Subject: 387 Ballard Road  
Fuquay Varina, NC 27526  
Plan Revision Letter  
Harnett County Permit #: SFD2302-0043

Based on the request of the Contractor, 2 items on the plans will be revised. My assessment and recommendations are as follows:

S2 FIRST FLOOR FRAMING
 1/4"=1'-0"

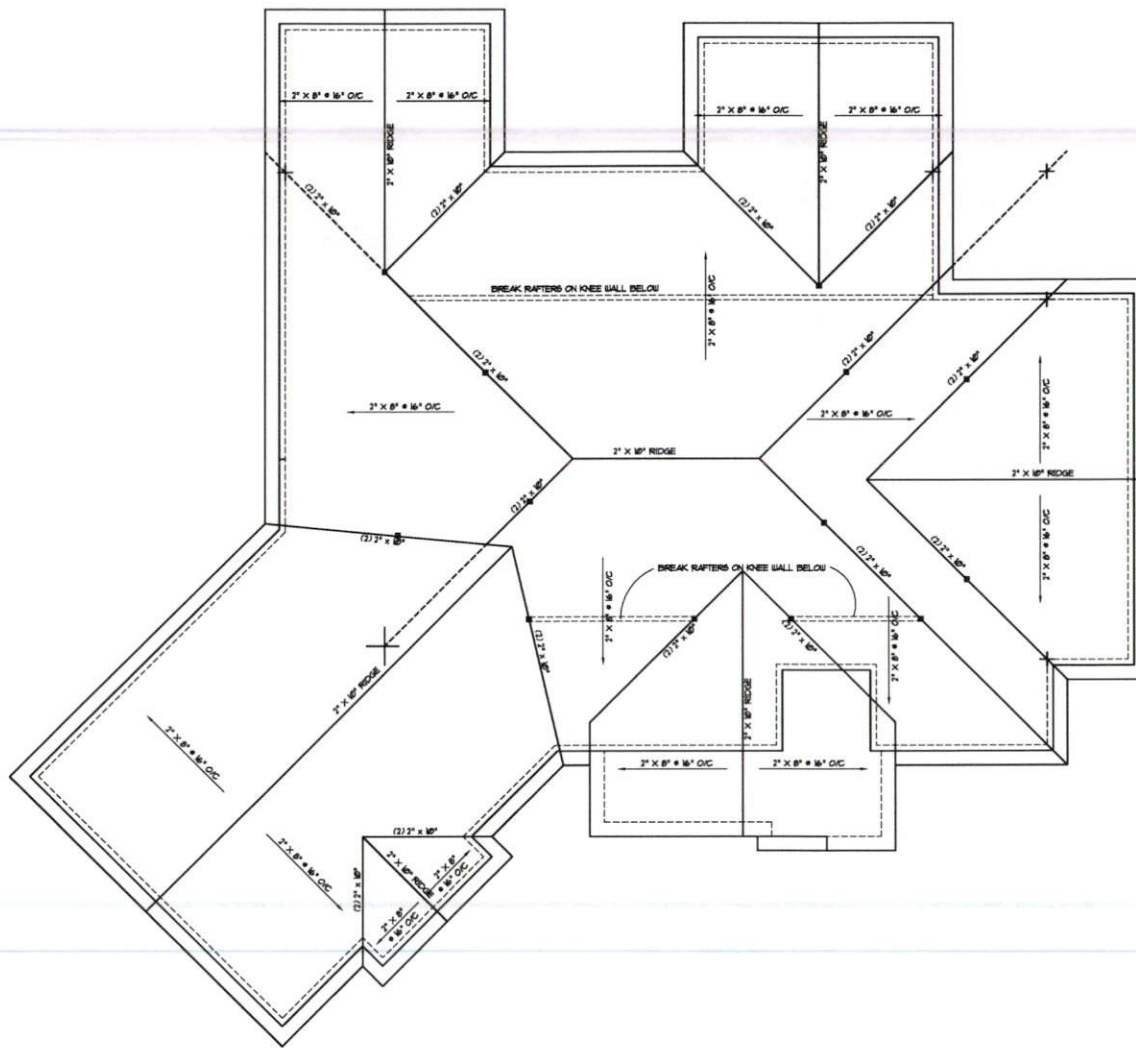
- Item 1 - The 2x12 ceiling joists next to the stairs to the Bonus Room are attached to the 2x12 band joist with Simpson LS90 brackets. This attachment is acceptable.
- Item 2 – The stairs to the Bonus Room extended past the load bearing wall of the Garage into the floor framing. A double 2x12 will be added at the end of stairs and on each side of the stairs to support the double 2x12 of the stairs.
